Appeal Decision

Appeal Ref: APP/R5510/W/22/3309309

60 Long Lane, Ickenham, Middlesex UB10 8SZ

- The appeal is made under section 78 of the Town and Country Planning Act 1990 against a refusal to grant planning permission.
 - The appeal is made by Mr Veeru Parmar against the decision of the Council of the London Borough of Hillingdon.
 - The application Ref 70282/APP/2022/1143, dated 1 April 2022, was refused by notice dated 15 August 2022.
 - The development proposed is the demolition of the existing dwelling and erection of a two storey detached building with habitable roof space to provide 8 x 2-bed flats and 1 studio flat with associated amenity space and parking.
-

PROPOSED FLOOR PLANS

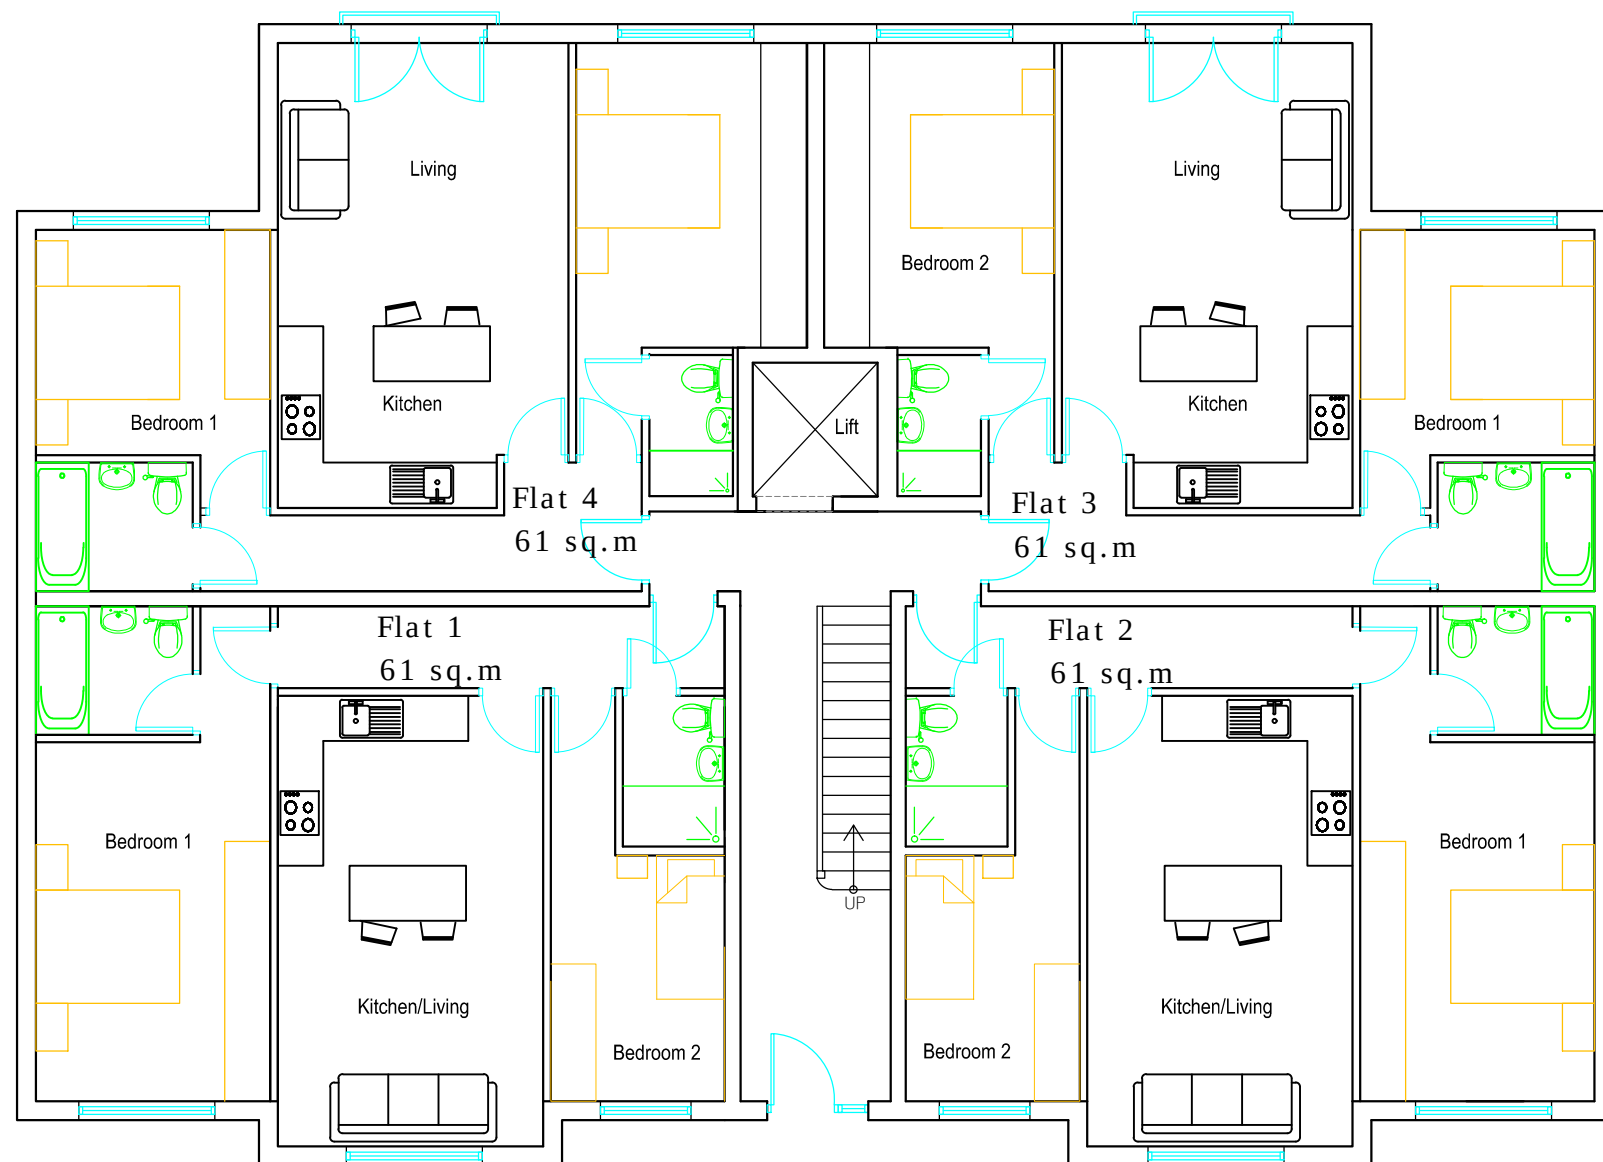
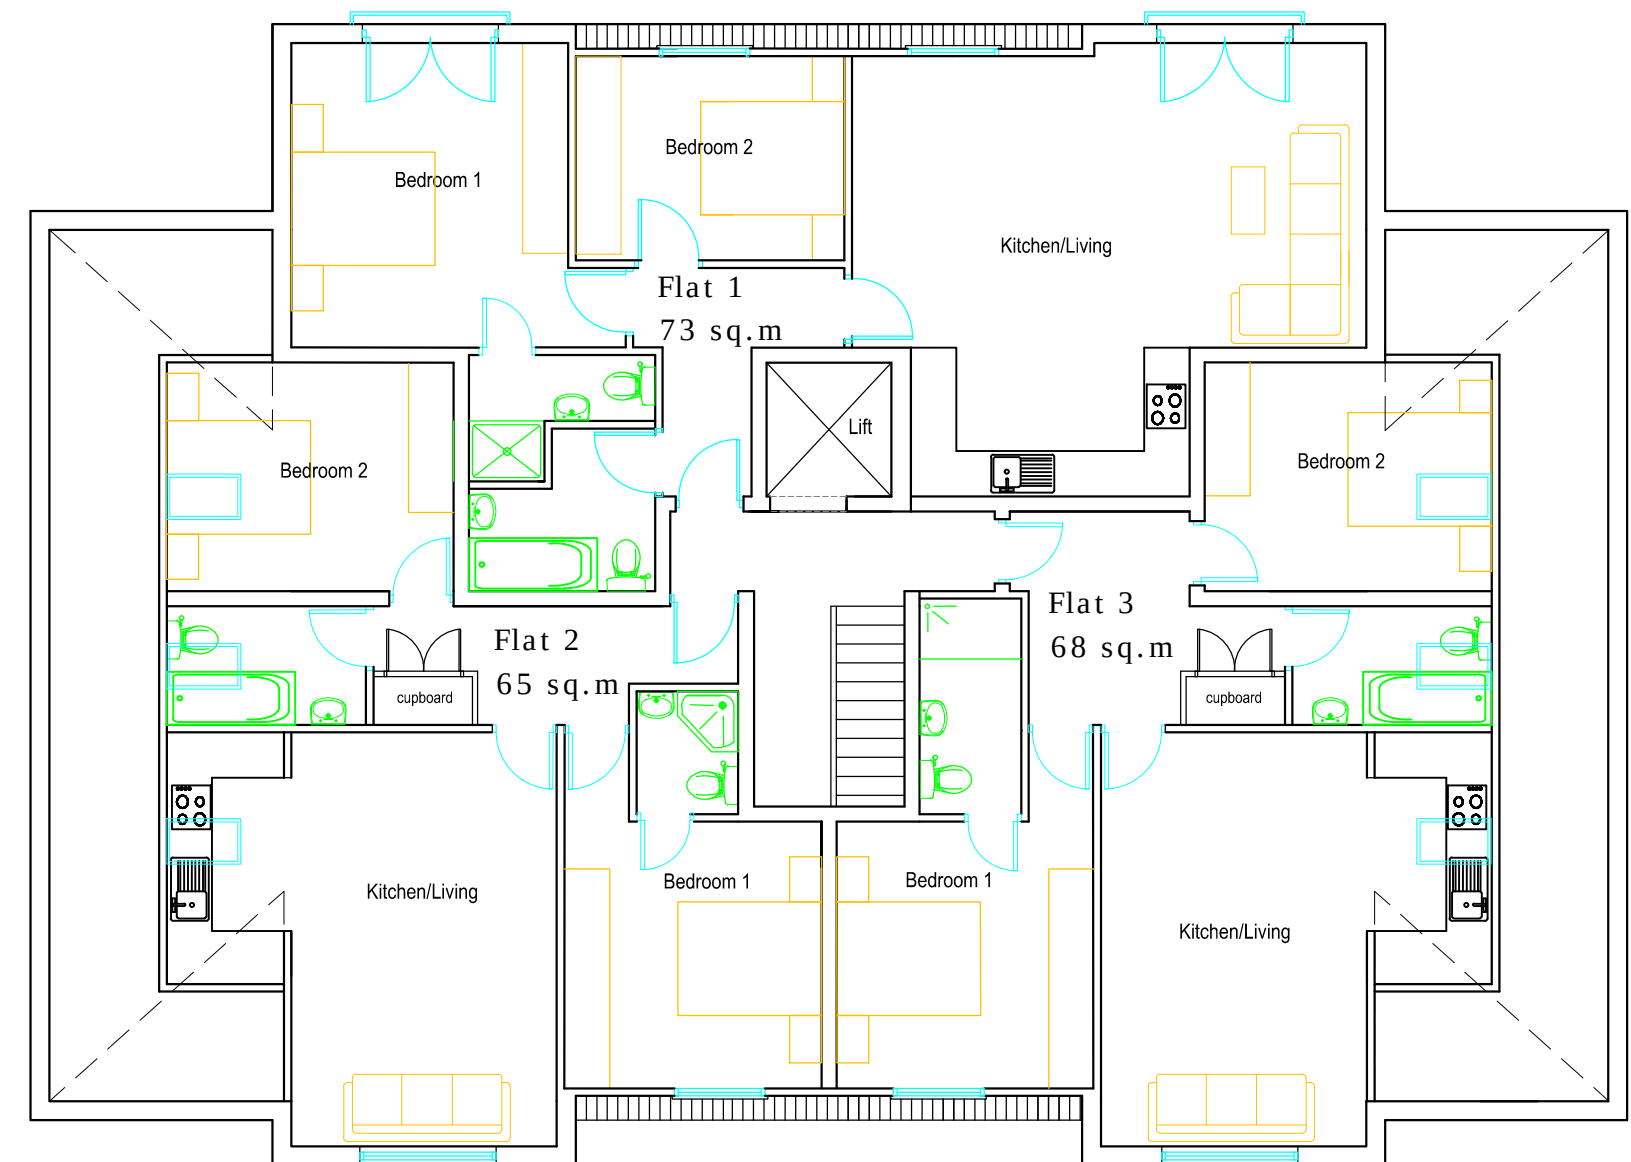
23. The Council contend that proposed flats 1, 2, 5 and 6 each have a single bedroom with a floorspace that would fall under the minimum 7.5m² standard. The appellant has not directly disputed this or provided evidence that would undermine the Council's finding. Hence, on the information before me, the floor space of the single bedrooms in these units would unacceptably compromise the living conditions of future occupants and would conflict with the development plan requirement in this regard.

Plan 746.17.1 Tree Constraints Plan

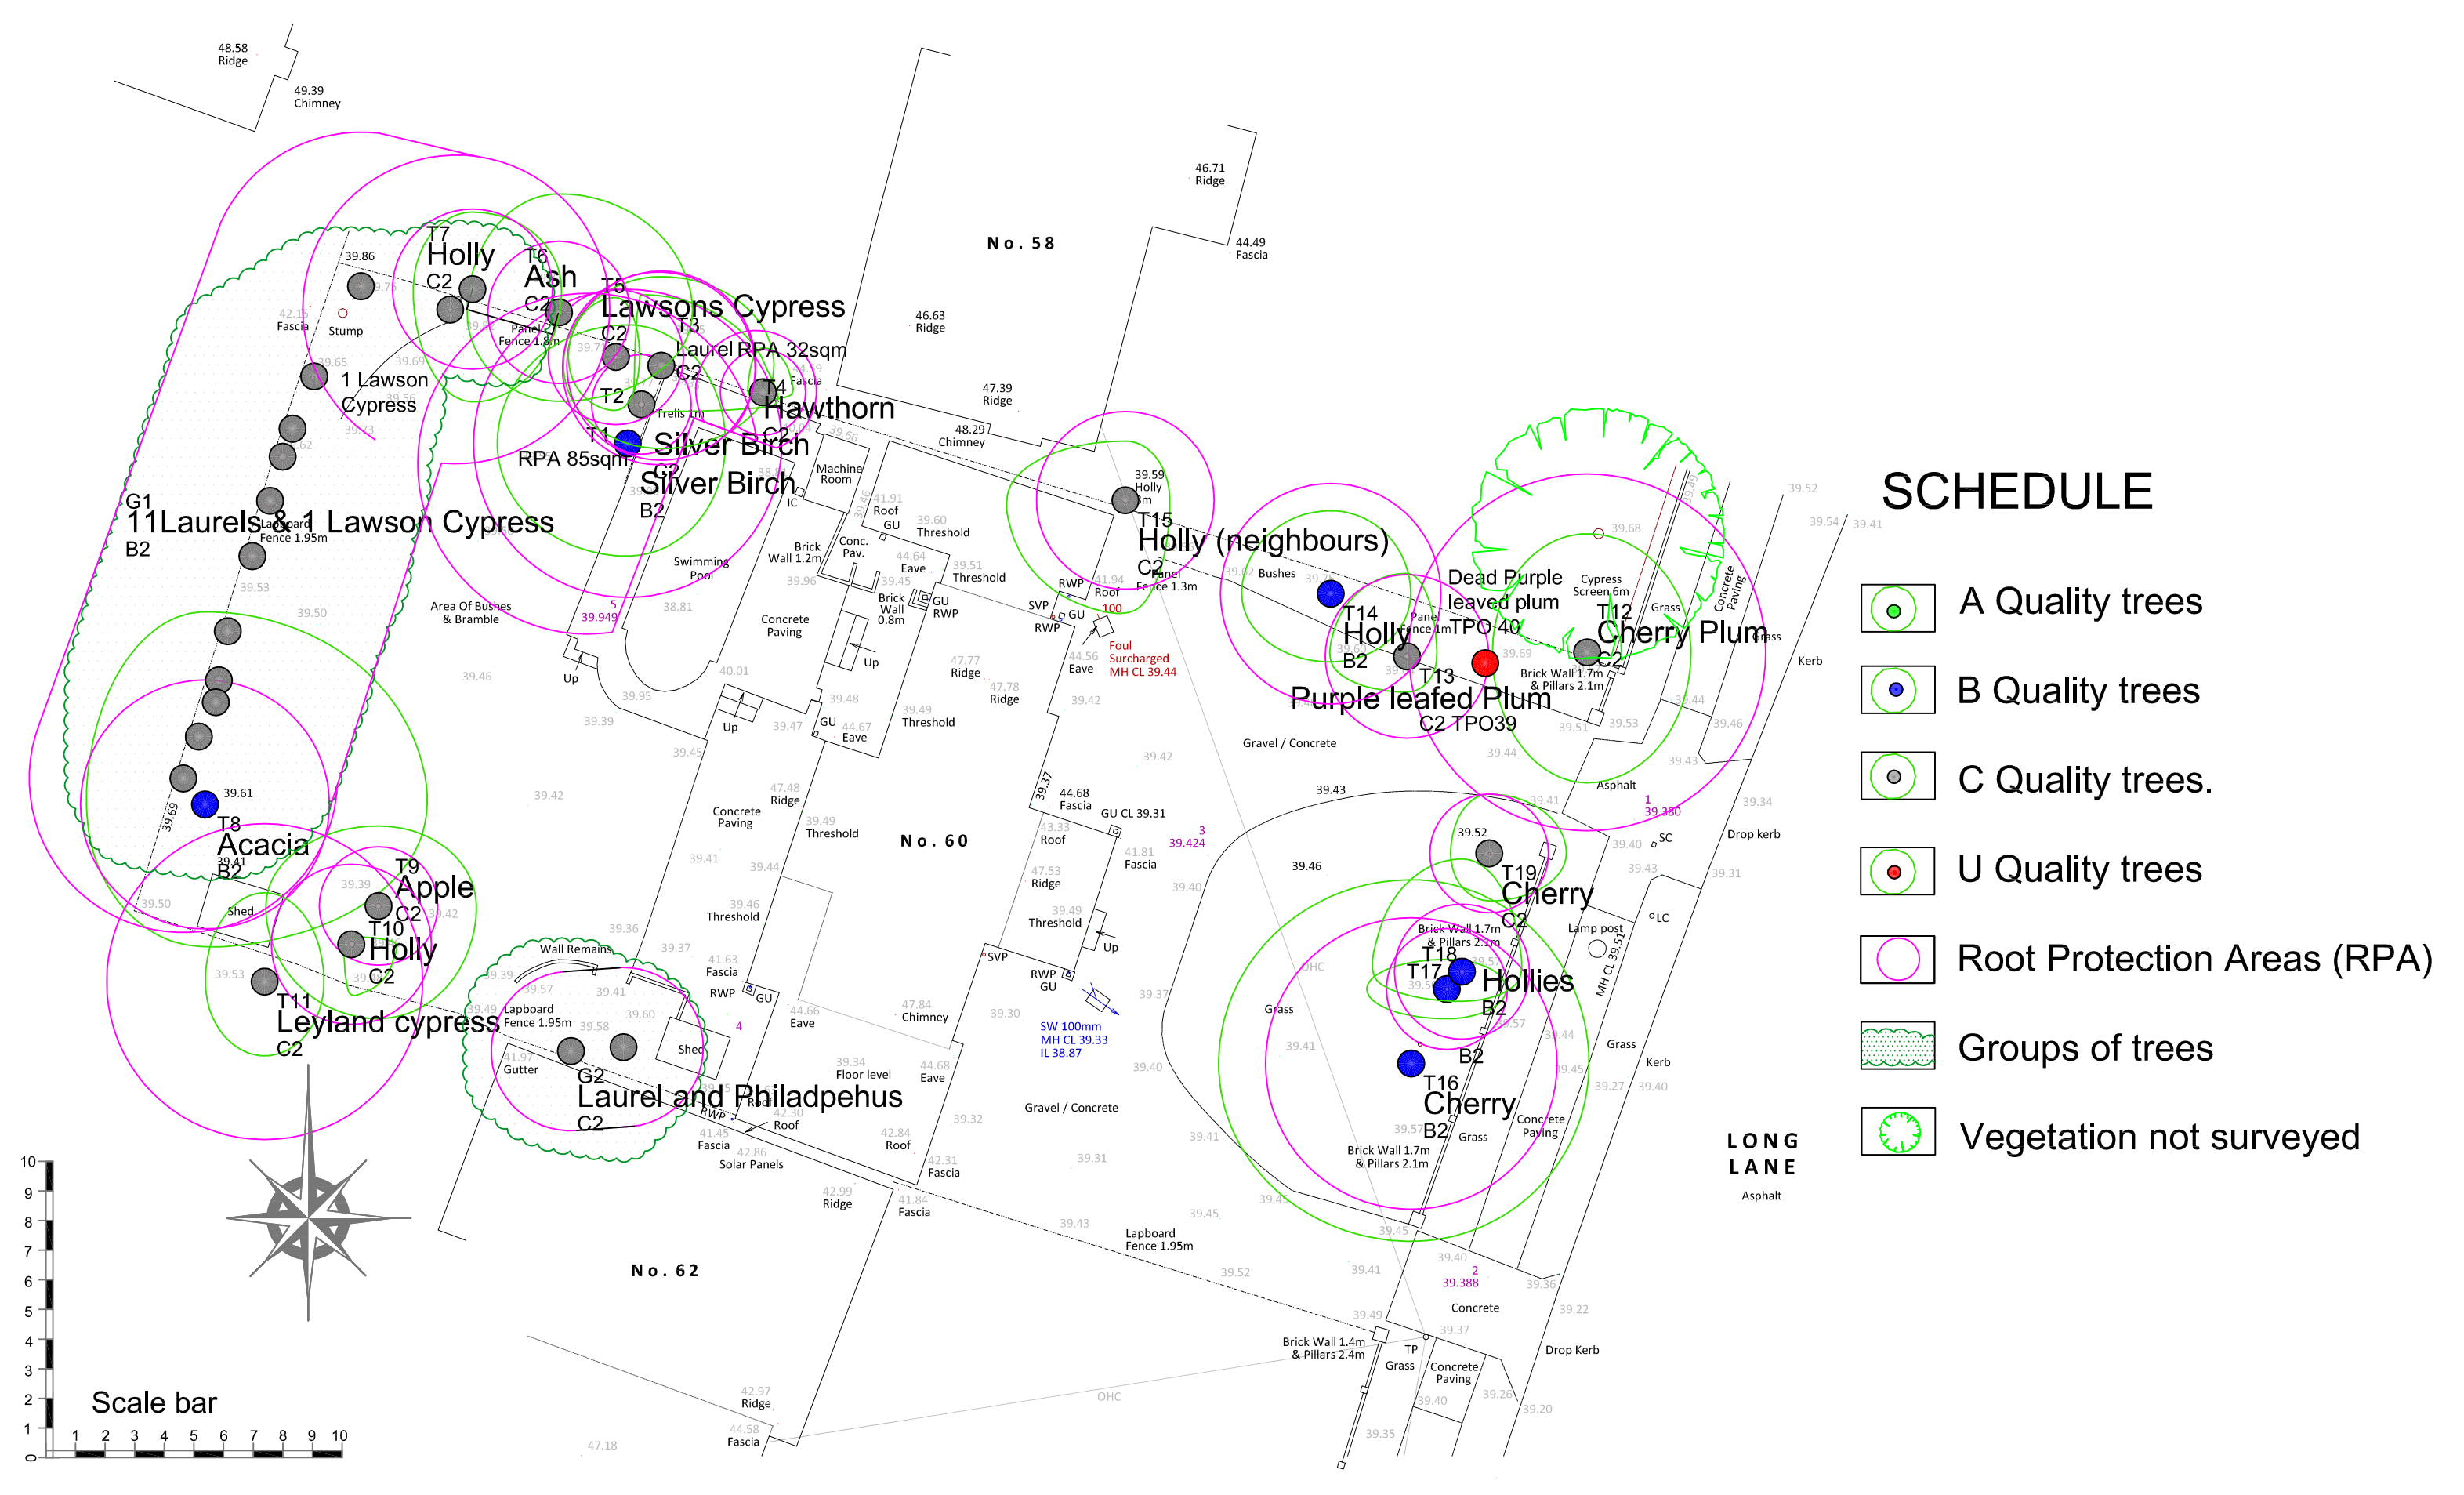
15. In addition, the amount and quality of tree cover contributes positively to the character and appearance of the CA and the appeal site is covered by a Tree Preservation Order. Tree information⁹ accompanies the application that includes a tree constraints plan showing the site has a notable number of category B and C quality trees. It is based on a survey of the trees undertaken in August 2017¹⁰. However, the report goes on to advise at paragraph 2.1.3 that if there is a change in site conditions it is important to re-survey the trees and re-evaluate them. In any event, the tree survey is only valid for a 3 year period from the date of the survey, meaning it is now out of date. Moreover, I am not assured that the development shown on the tree protection plan
